**WEST SUSSEX COUNTY COUNCIL
PLANNING SERVICES CONSULTATION**

SUBJECT: A/155/17/OUT- Outline application with some matters reserved for 3 No. dwellings. This application may affect the setting of a Listed building & is a Departure from the Development Plan.

Avenals Barn, Water Lane, Angmering, West Sussex, BN16 4EP

PROPOSED SITE PLAN 1:200

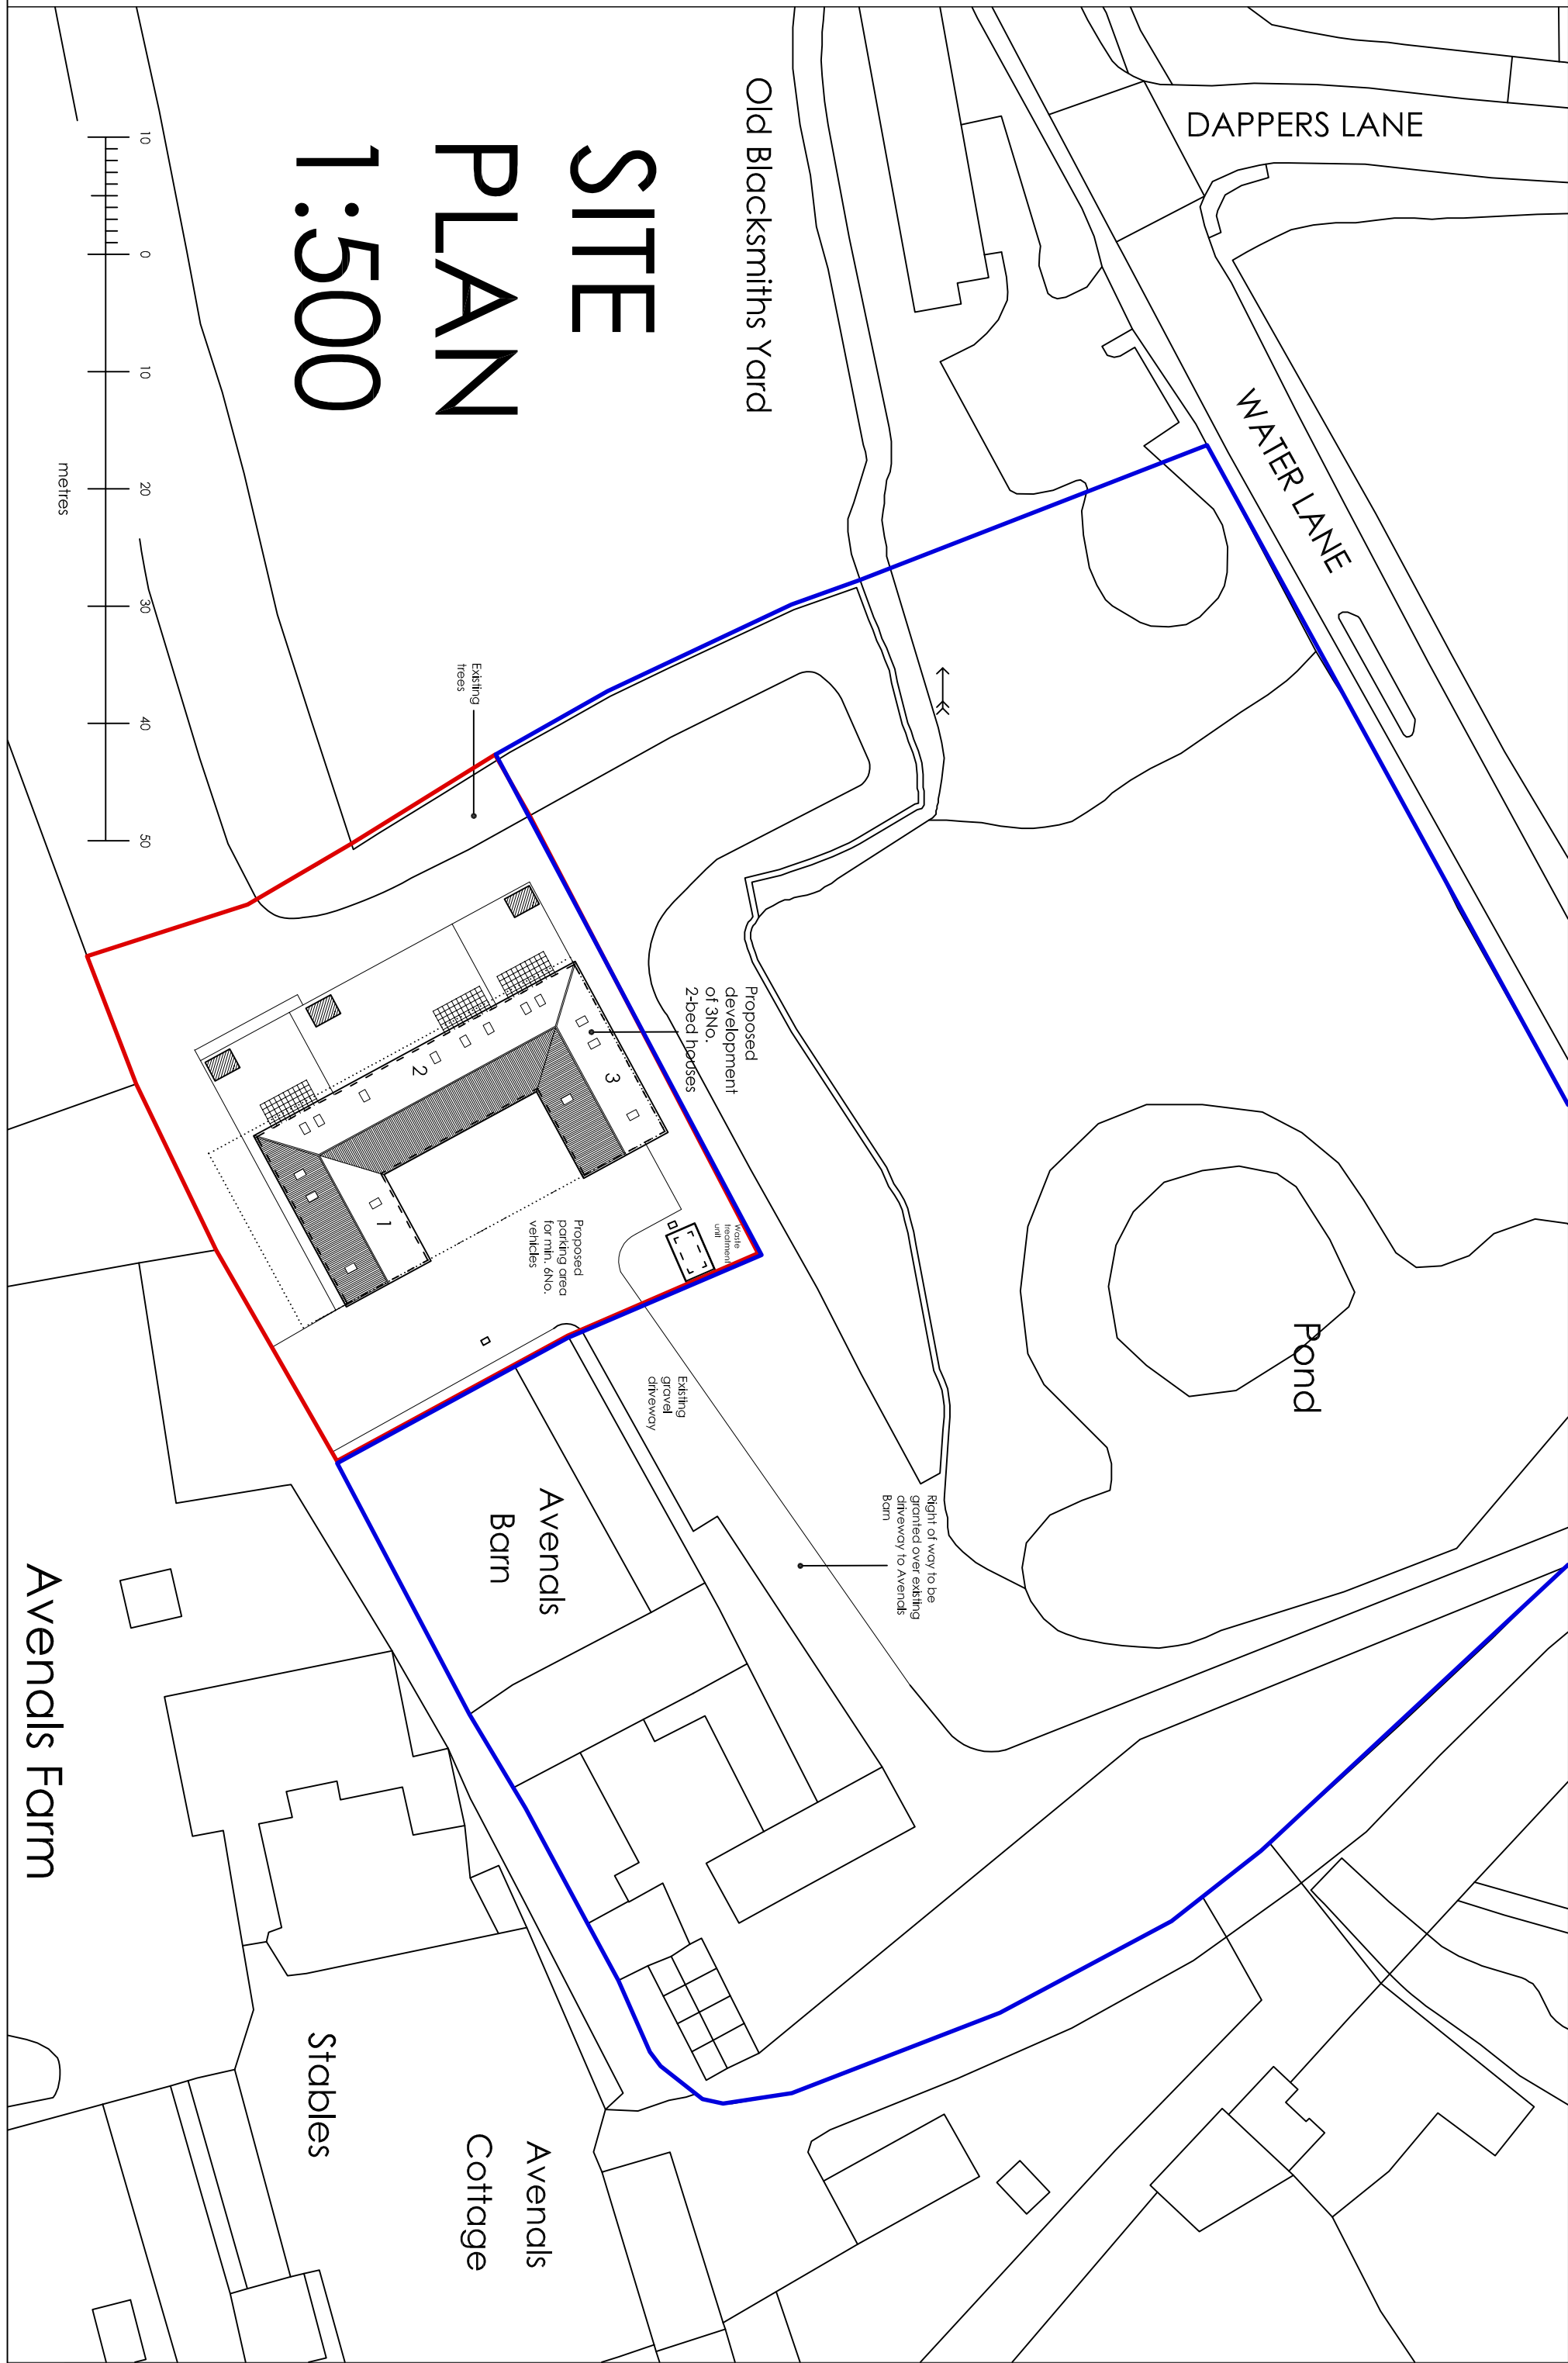
The proposed parking for this development is considered acceptable. The parking allocation is in accordance with the demand from the WSCC PDC (Parking Demand Calculator). From checking this and based on the proposed mix and tenure of the dwellings, the car parking provision is anticipated to satisfy the likely demands. The vehicular parking spaces should measure 2.4m x 4.8m in order to suitably accommodate an average size vehicle. The LHA also support the proposals to include a shed building which may be utilised as secure covered cycle parking for the new dwelling.

Refuse bins are to be located within a communal store within the site. It has not been stated whether refuse will be collected from this point or if refuse bins will be wheeled to the roadside by residents. Should the applicant be anticipating refuse collection from within the site, further information will be required in the form of a swept path diagram to demonstrate that space will be available for refuse vehicles to exit the site in a forwards gear onto Water Lane.

It is anticipated that the proposed dwellings will follow the same practise as existing residents and wheel bins will be taken to the access point onto Water Lane on collection day. The LHA refer to Manual for Streets (MfS) guidance which states that residents should not have to walk in excess of 30m with their bins where at all practical to a designated refuse collection point. Though this is not a Highways Safety concern, the LPA may wish to consider this amenity issue. The LHA also advise that the applicant contacts the relevant waste disposal authorities to discuss the suitability of the proposed.

No part of the development shall be first occupied until the vehicle parking and turning spaces have been constructed in accordance with the approved plan. With spaces measuring 2.4m x 4.8m each. These spaces shall thereafter be retained for their designated use.

No part of the development shall be first occupied until covered and secure cycle parking spaces have been provided in accordance with plans and details submitted to and approved by the Local Planning Authority.
